RE : Objection to State Significant Development (SSD) / Proposal for 10-storey residential apartment building at 40 – 48 Redan Street, MOSMAN SSD-93020230

I am writing to strongly oppose and formally lodge my objection to the above proposal for a 10-storey residential apartment building at 40–48 Redan Street, MOSMAN on the following planning grounds.

Scale 1:250 @ A3	Code TPRS	Sheet 2801	Rev B	0 2.5 5 10m	
---------------------	--------------	---------------	----------	-------------	--

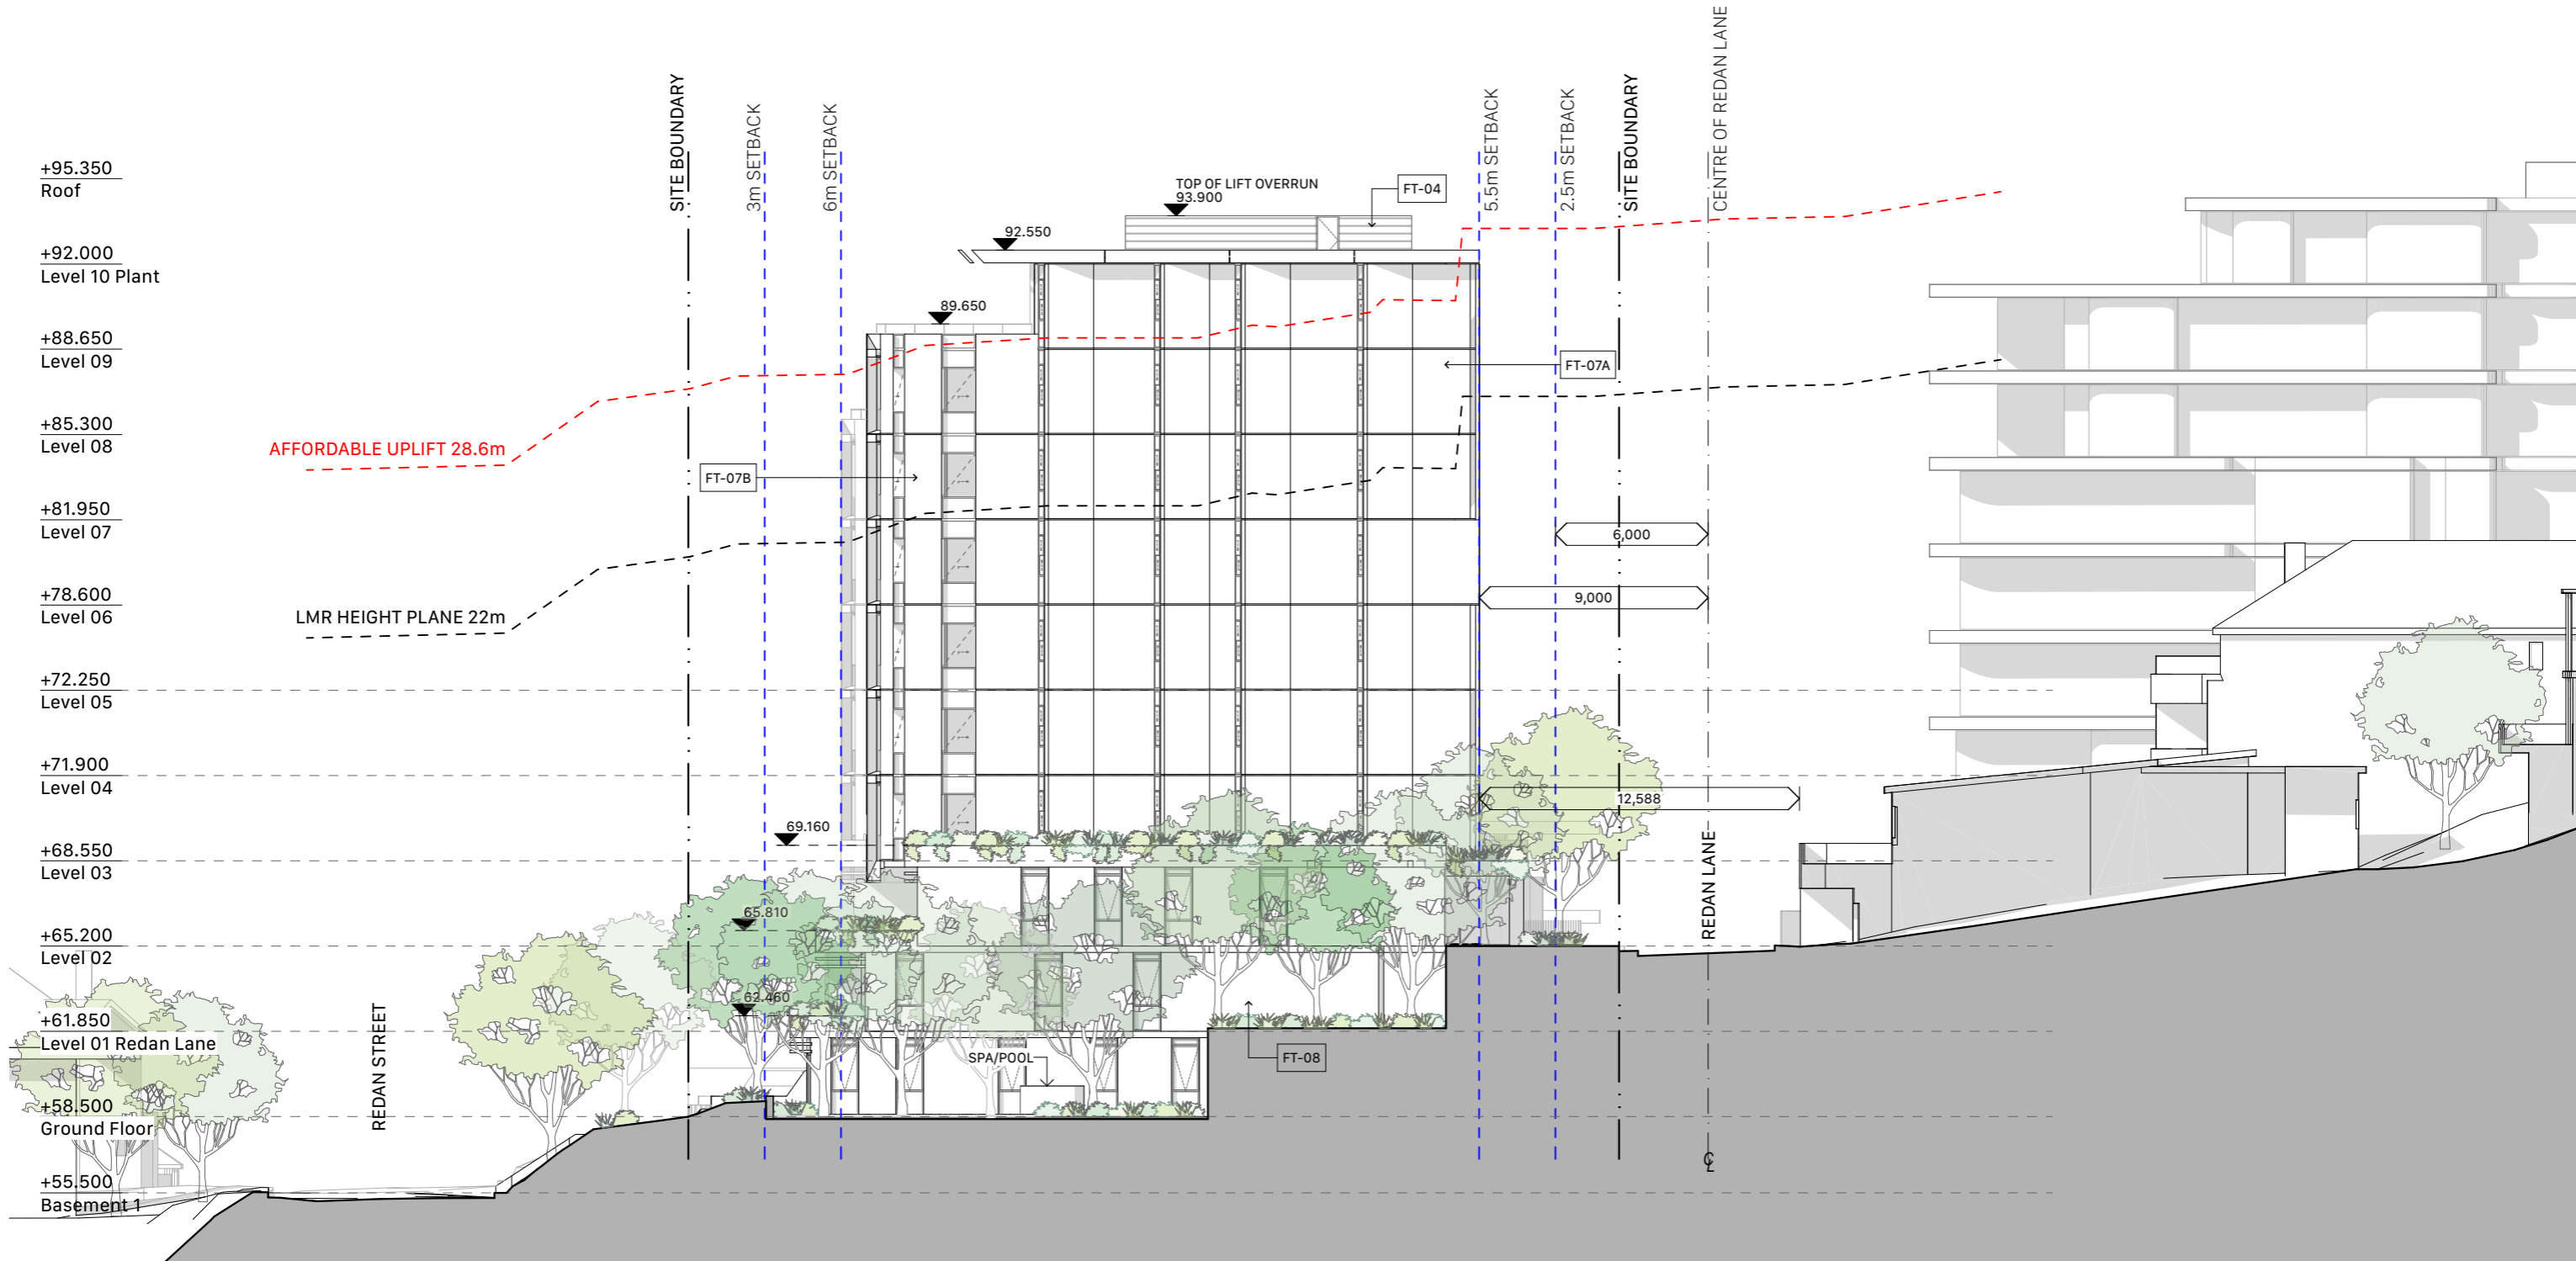
Refer FJC Studio Drawing Sheets 2800B and 2801B

Proposed Total Floor Space Area is	9,214.8m ²
Proposed Affordable Housing Floor Space Area is	1,353.9m ²

Therefore Affordable Housing component of development is $1,353.9 \div 9,214.8 = 14.69\%$

The Site Area is	3,233m ²	
Allowable Floor Space Area 2.2 x 3,233 =		7,112.6m ²
Plus 30% additional FSR for Affordable Housing		<u>2,133.8m²</u>

TOTAL PERMISSABLE FSR (including Affordable Housing 30% bonus)	9,246.4m²
---	-----------------------------

The proposal seeks approval for a Total Floor Space Area of 9,214.8m².
However this includes the **Affordable Housing 30% bonus** .
